Application by Tritax Symmetry (Hinckley) Limited for an Order Granting Development Consent for the Hinckley National Rail Freight Interchange – Deadline 6 submission

Hinckley National Rail Freight Interchange

Leicestershire County Council Design Review Comments as presented to the Applicant team on 14.02.2024 and as discussed at a meeting with the Applicant team on 15.02.2024

Project - Originator - Zone - Level - Type - Role - Number	Status	Rev
HRF-BWB-HGN-HW06-DR-CH-0115	S2	P01

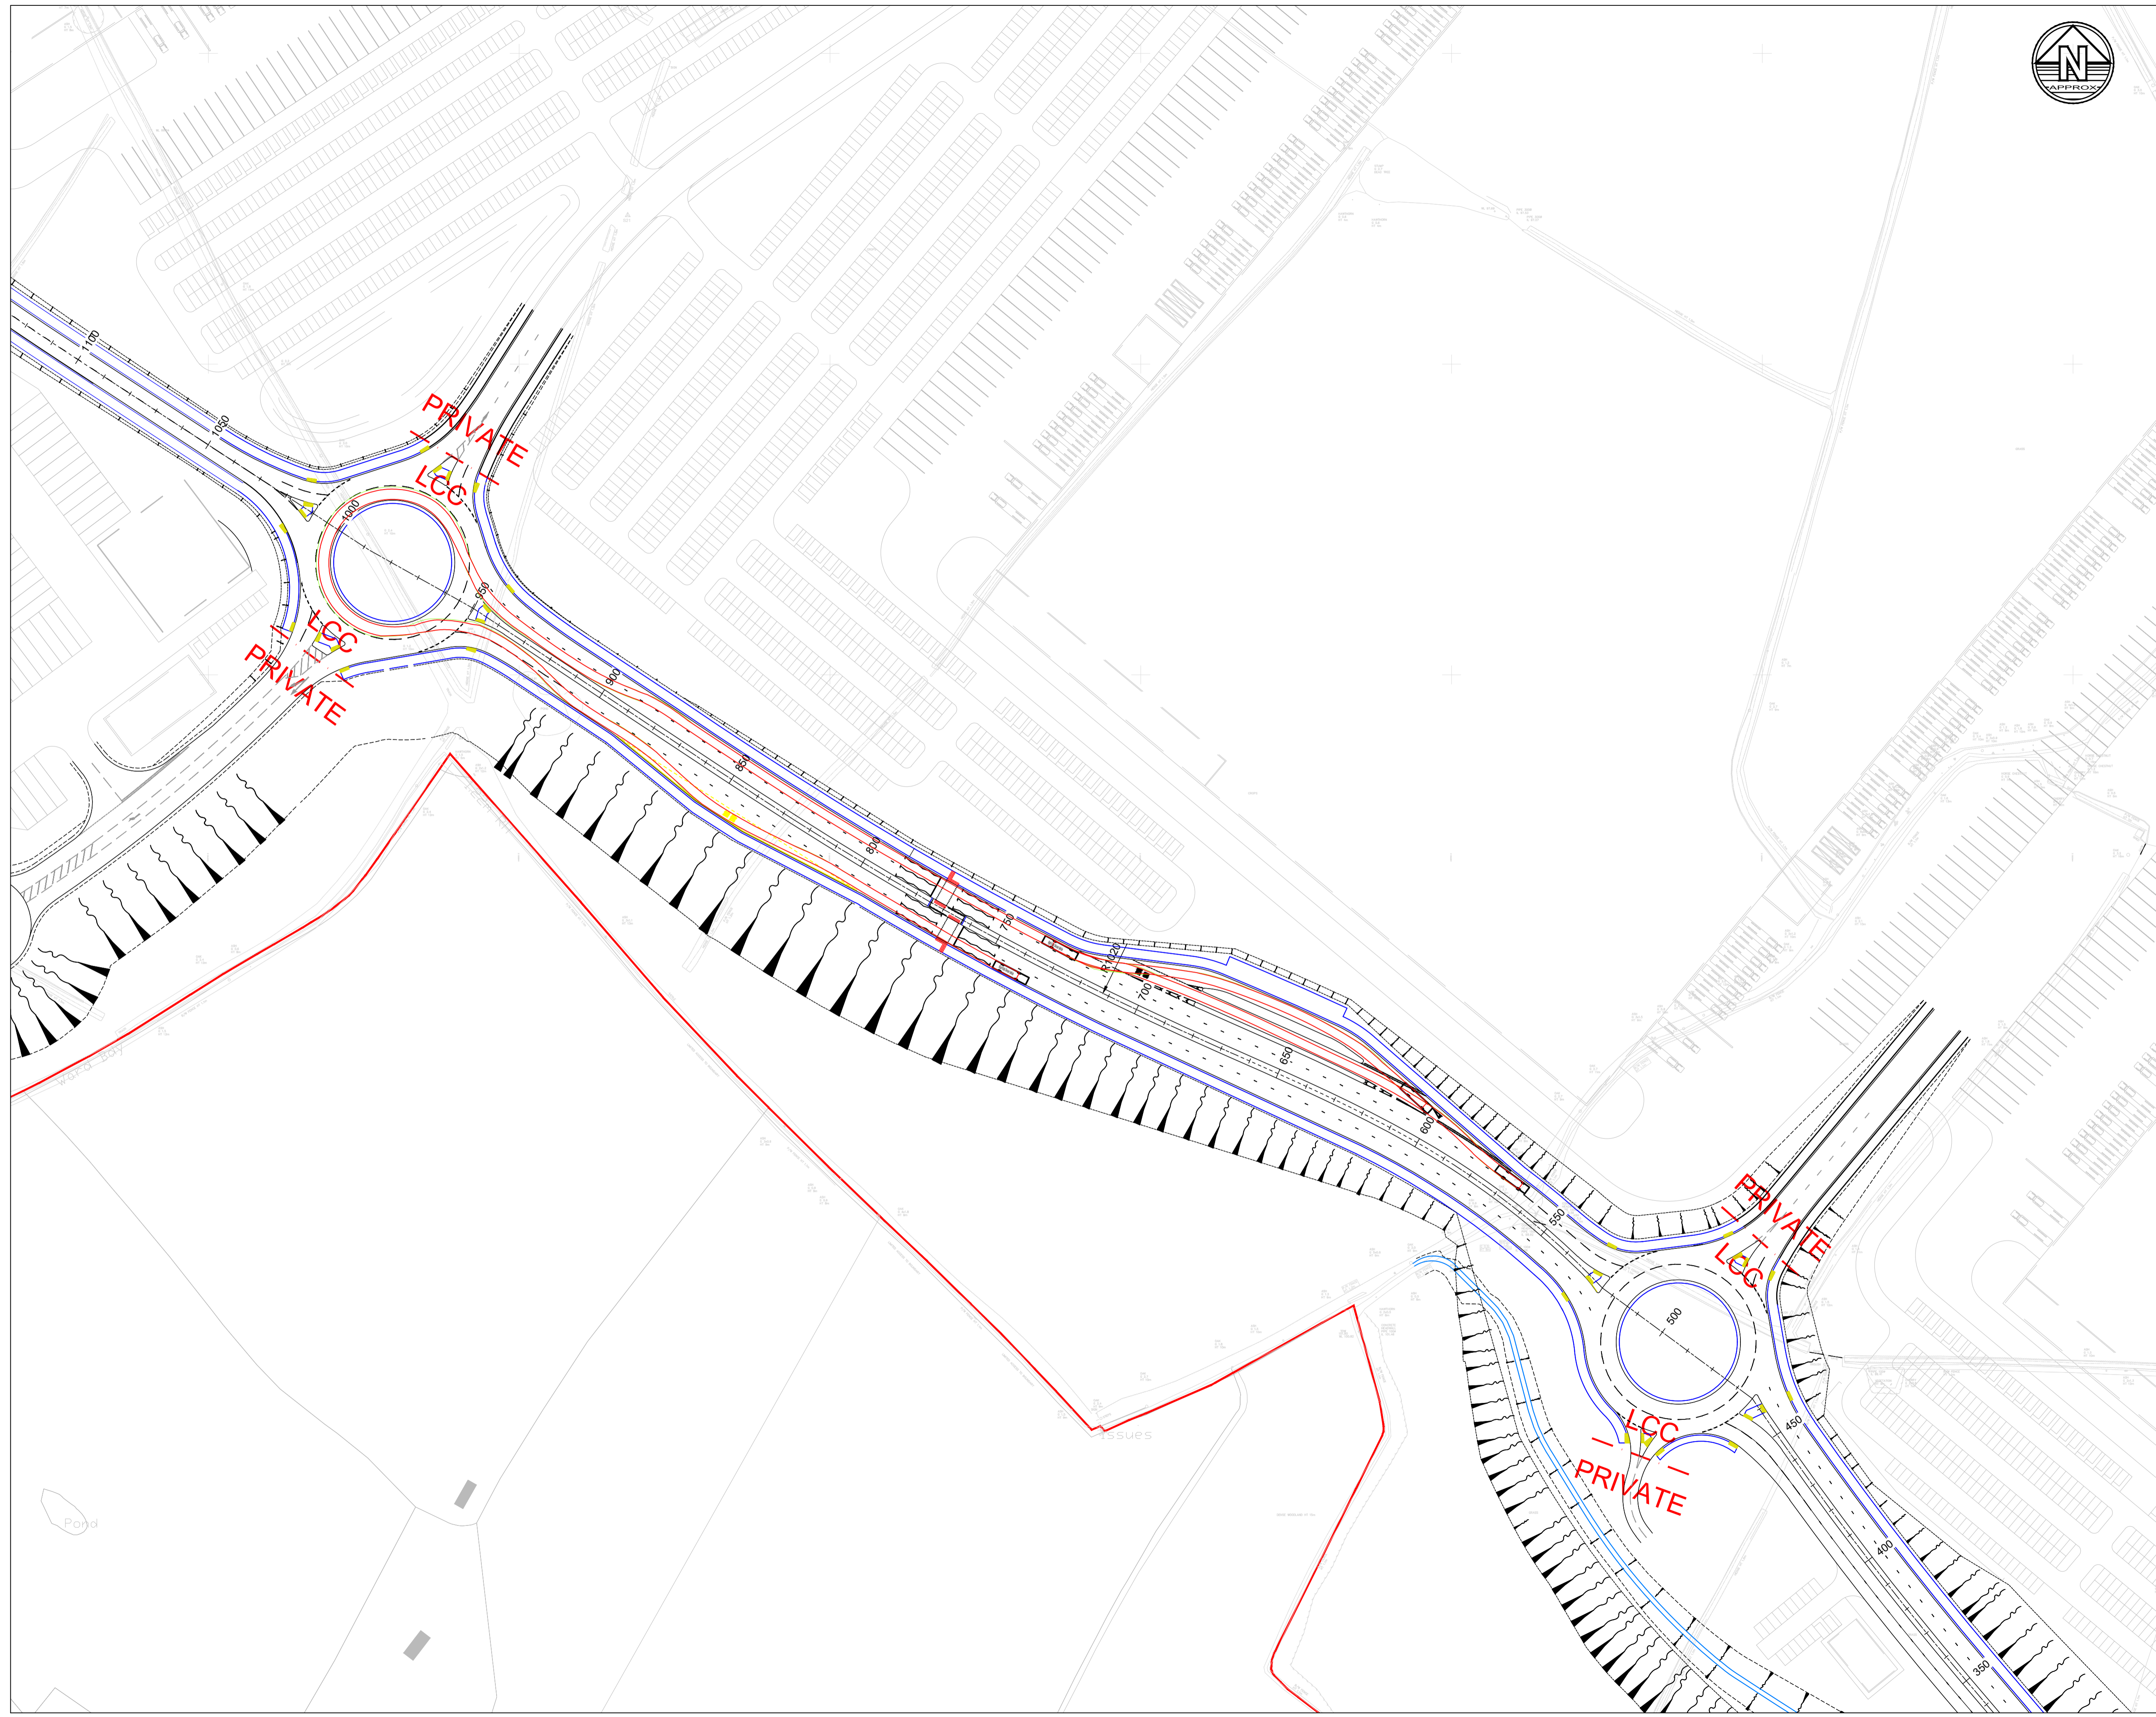
- 2.6.1 Approach visibility SSD to roundabout give way line needs to be shown to each arm.
- 2.6.2 Stepped accesses to bridleway to be removed.
- 2.6.3 Splitter Island layouts shown on South-West and North-East arms are incomplete.
- 2.6.4 Vehicle tracking analysis has been provided on Dwg No HRF-BWB-HGN-HW06-DR-CH-0115 and indicates multi-lane manoeuvres for the Max Legal Articulated vehicle. Tracking

appears acceptable although clarification required from the designer as to the speed setting used for the tracking analysis (to be advised on the drawing).

Project - Originator - Zone - Level - Type - Role - Number	Status	Rev
HRF-BWB-HGN-HW01-DR-CH-0100	S2	P02

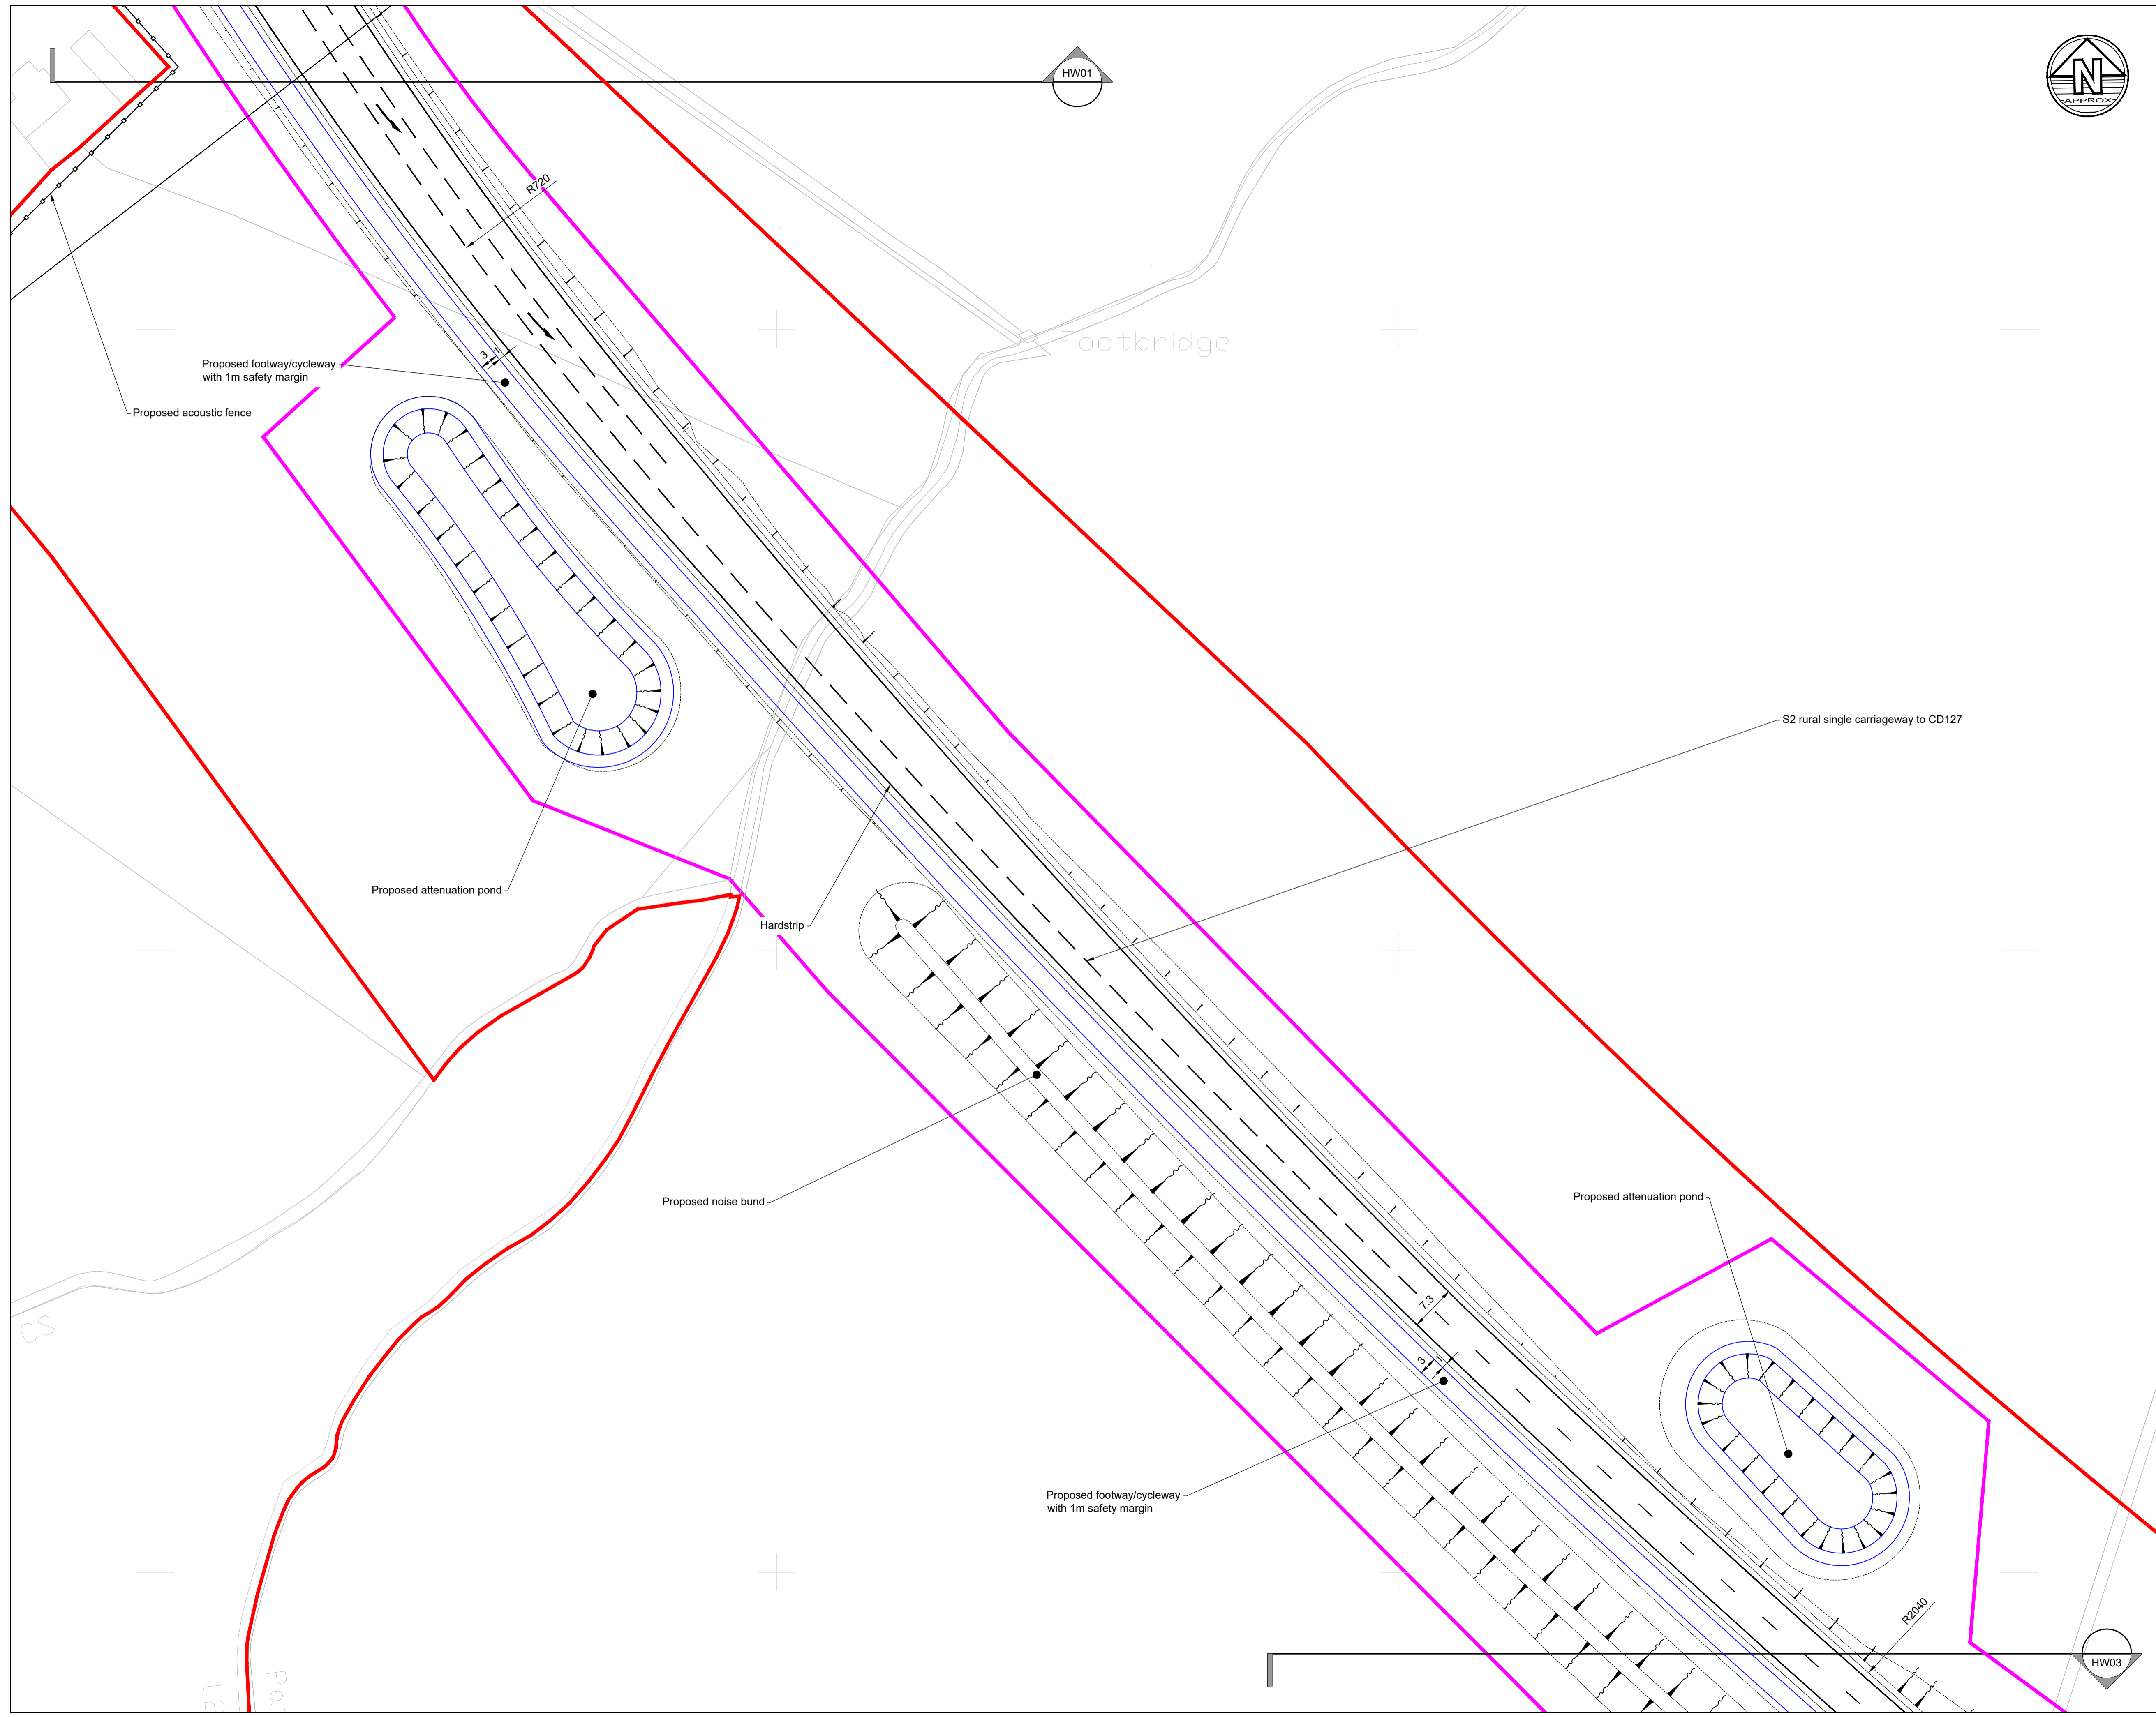
- 2.1.1 Forward visibility (SSD) to proposed give way lines at the roundabout needs to be shown.
- 2.1.2 Geometric Design Strategy Record (GDSR) document advises design speeds of 70 kph based on 40mph speed restriction for vehicles approaching in a South-Westerly direction. This length of B4668 currently has a 50mph speed restriction and so proposed design speeds on the existing B4668 should be supported by 85th %ile speed measurements. Although it is proposed to extend the existing 40mph speed restriction to the South-West of the proposed roundabout, there would be no guarantee that this would sufficiently reduce speeds where required.

- 2.1.3 Clarification required regarding ICD and central island diameters. The GDSR indicates a central island diameter of 30m but this appears to be 28m on the plan based on the entry path radius shown. Has the roundabout got a 1m overrun strip?

- 2.1.4 The approach taper for the diverge into the segregated left turn lane needs to be shown.
- 2.1.5 No vehicle tracking appears to have been provided, and this must be submitted for review, taking into account multi-lane manoeuvres around the junction.

- 2.1.6 Forwards visibility splays over the required SSD need to be shown to demonstrate compliance with CD116. The splay would need to be within the proposed highway boundary.

- 2.1.7 On the North-Eastern arm the tie-in to the existing central hatched markings needs to be shown.
- 2.1.8 On the proposed A47 link road the speed restriction is shown as increasing from 40mph to derestricted approximately 100m South of the B4668 roundabout junction. There is concern that that this would encourage higher vehicle speeds in a location where vehicles are merging from 2 lanes to 1.

- 2.1.10 No interim RSA information appears to have been provided for this proposal, and this would need to be submitted along with designer's response to any problems raised.

- 2.1.11 Potential safety concern at the proposed access for G&T site. More detail is required to ensure vehicles access and egress the site in a safe and controlled manner. Swept Path Analysis also required.
